**EL PASO COUNTY PLANNING AND
 COMMUNITY DEVELOPMENT
 DEPARTMENT**

GRADING AND EROSION CONTROL PLAN CHECKLIST

EROSION CONTROL BLANKET (ECB)

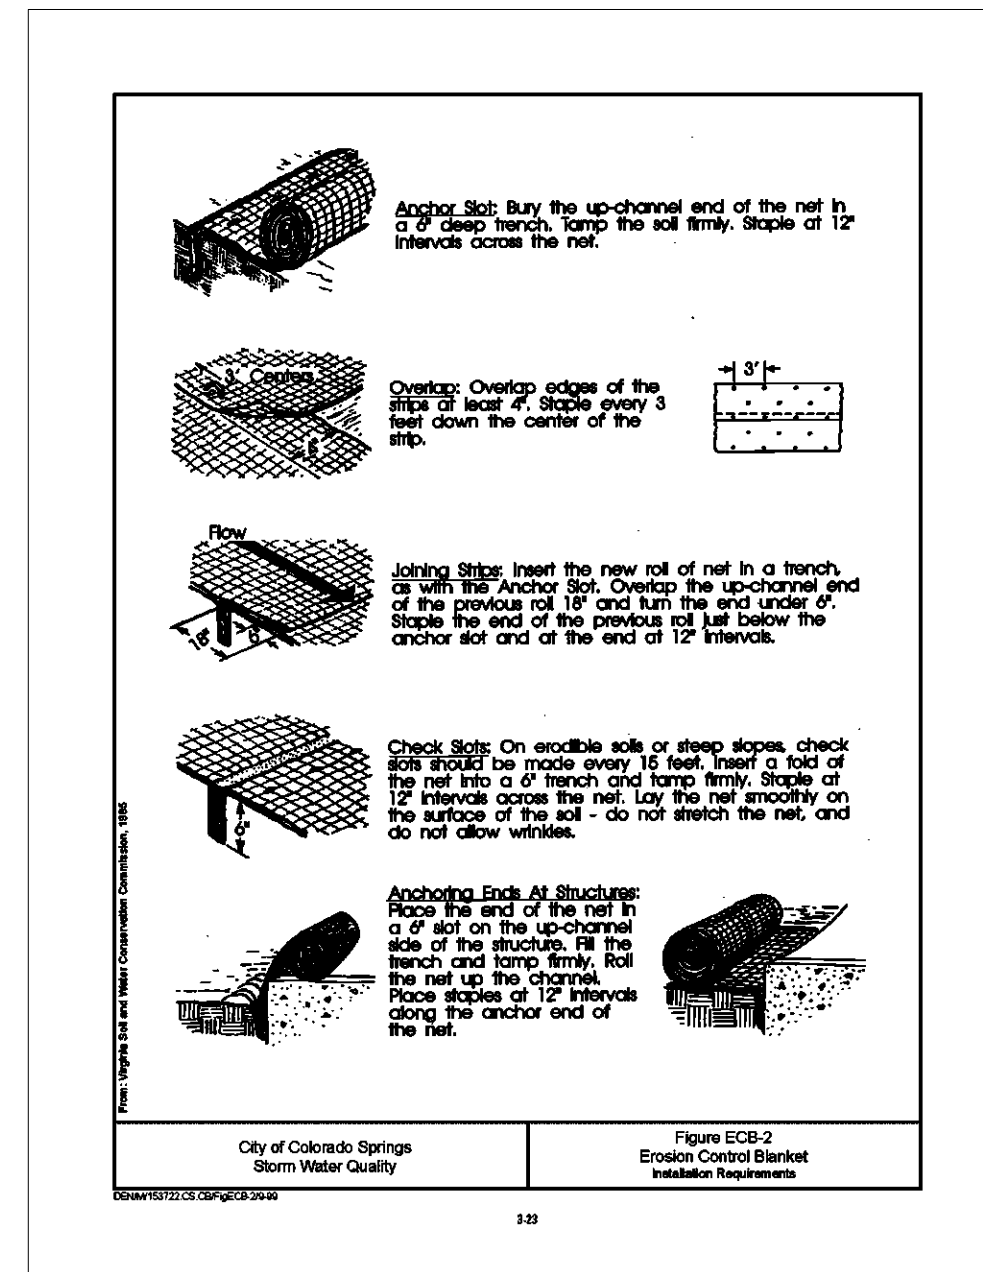
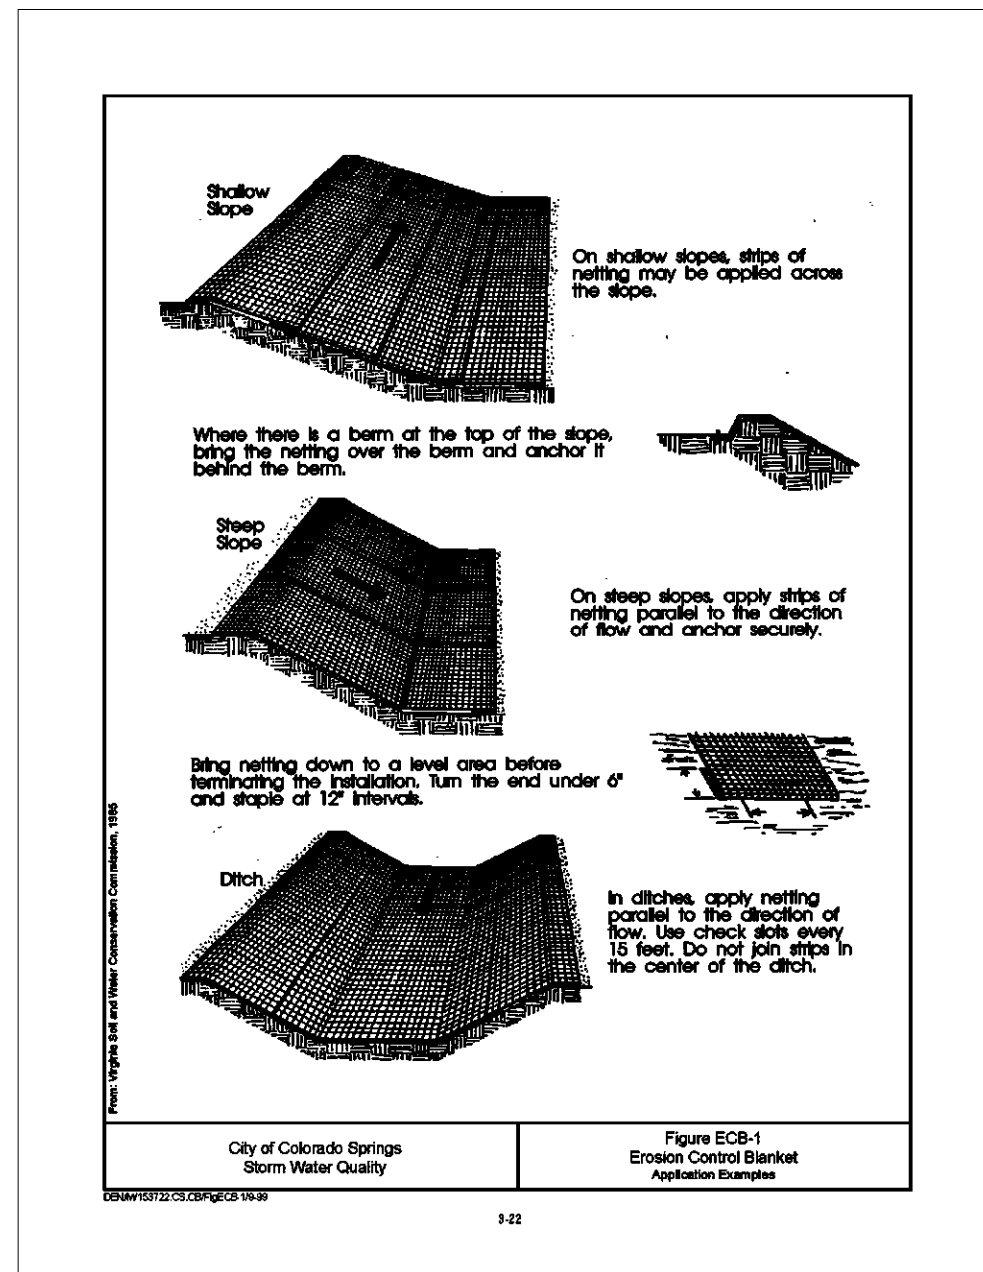
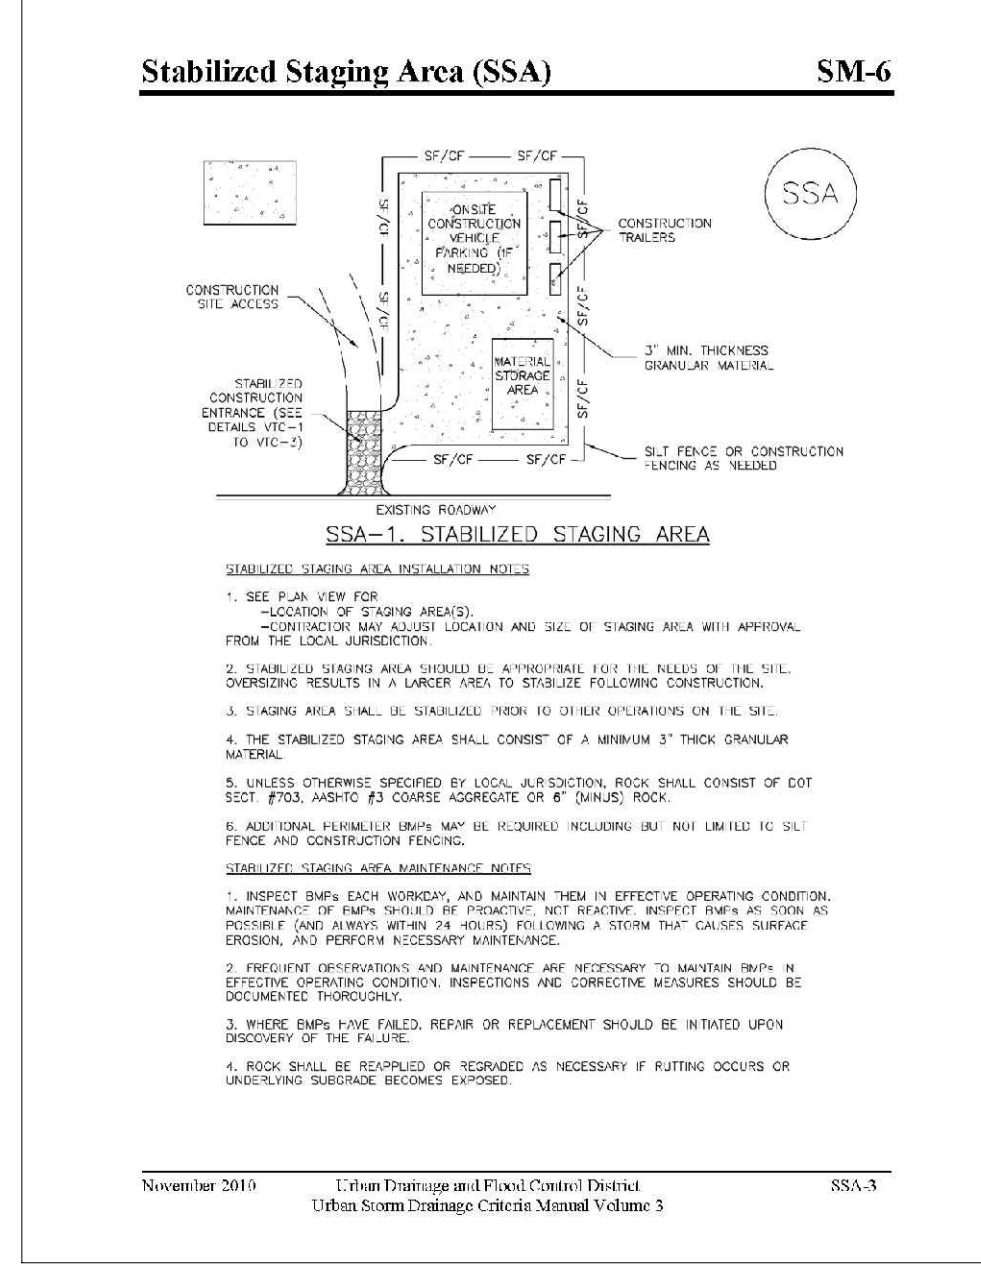
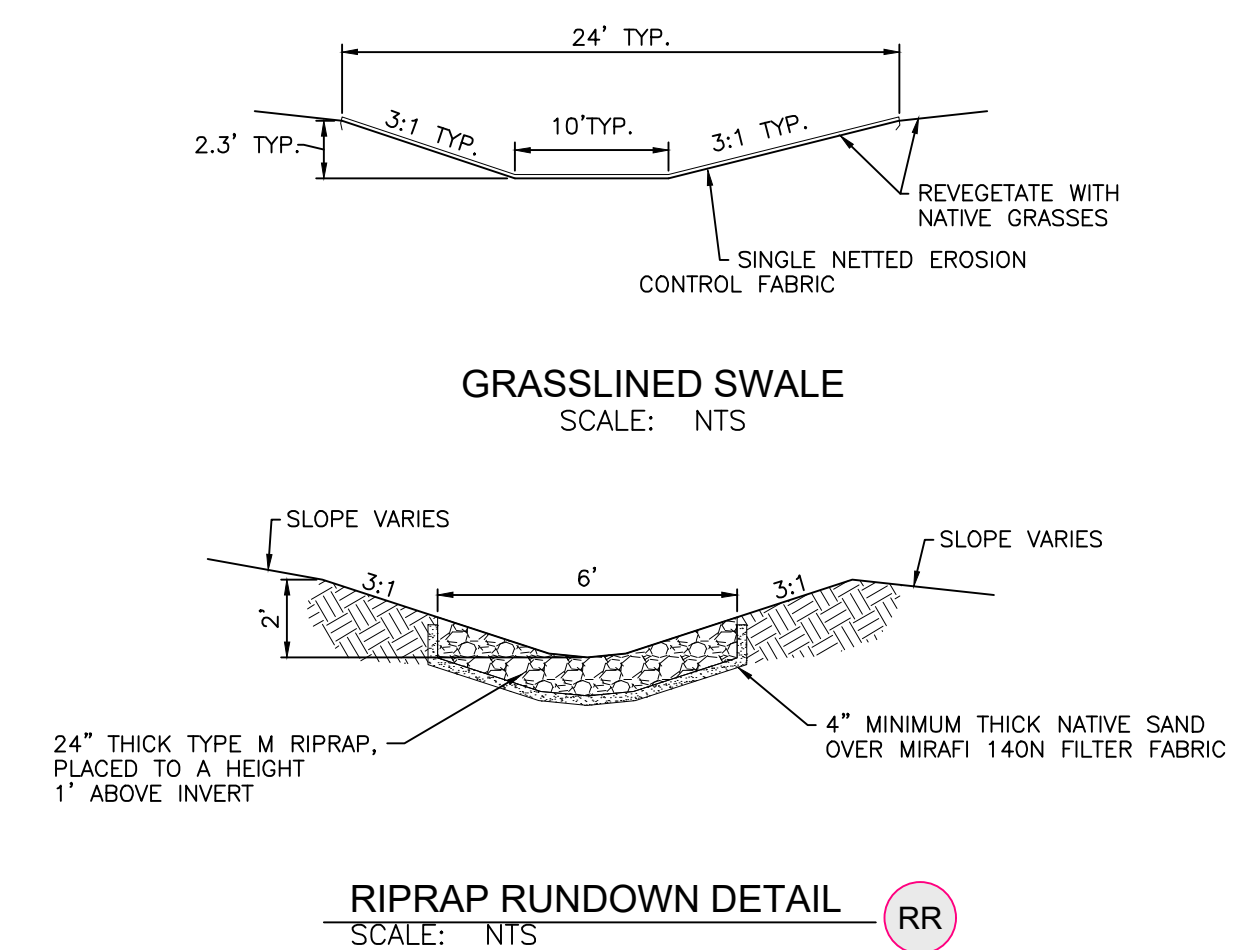
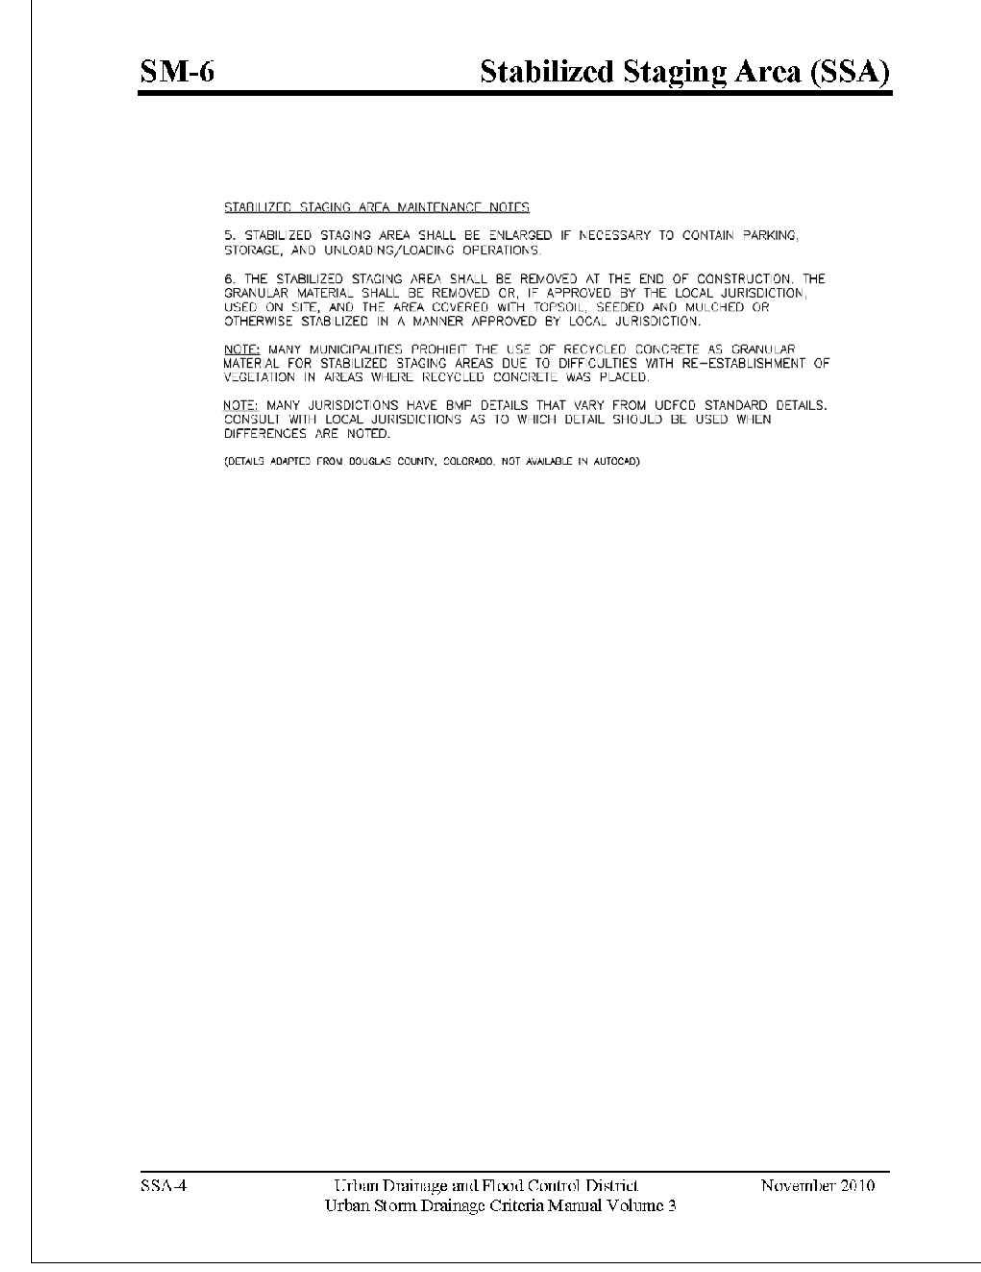
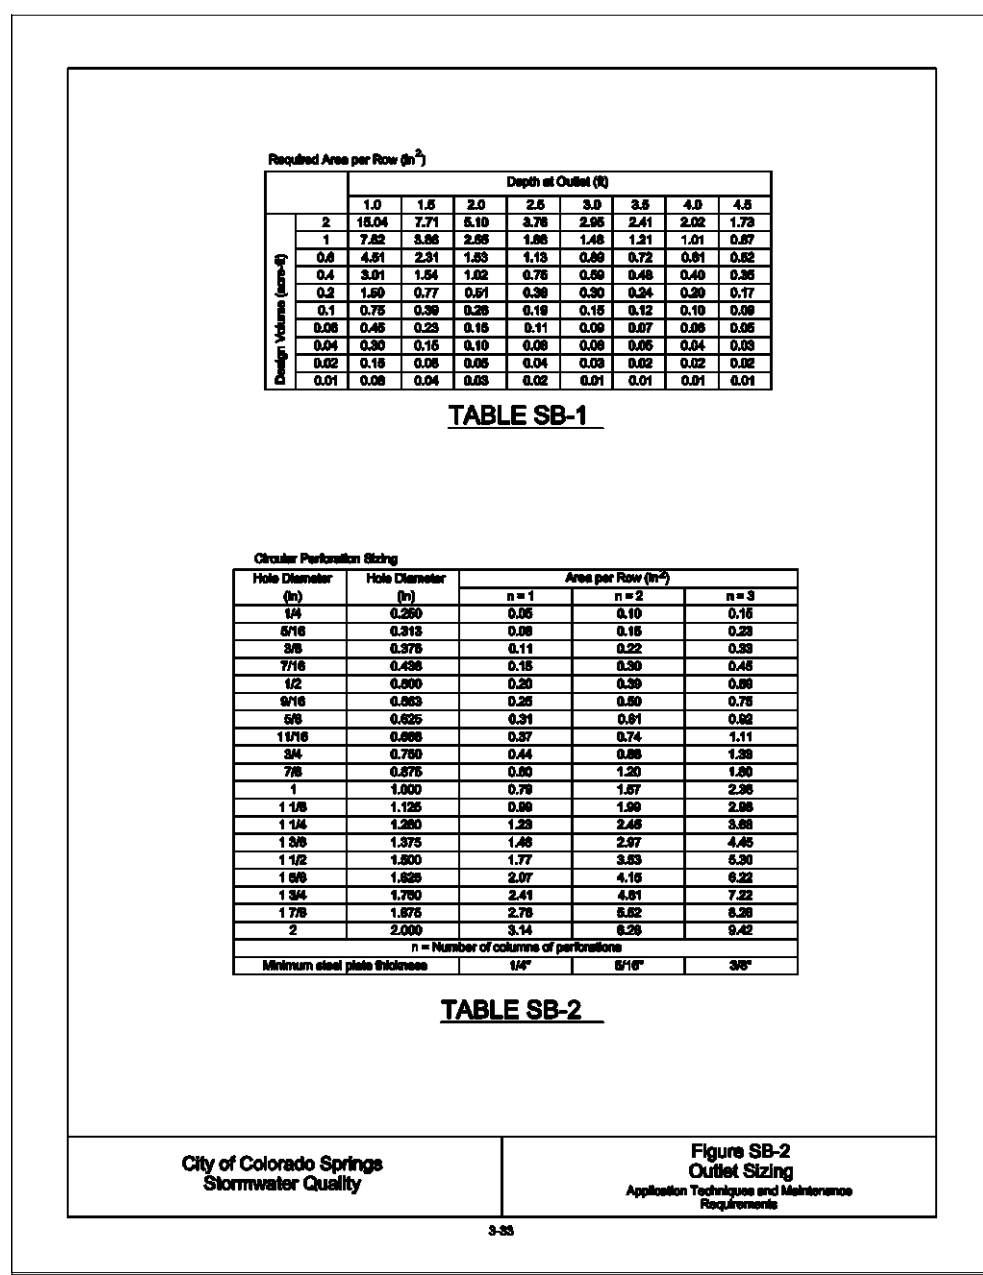
| | | Applicant | PCD |
|--|---|-----------|-----|
| z | All proposed temporary construction control measure details. Custom or other jurisdiction's details used must meet or exceed EPC standards. | X | X |
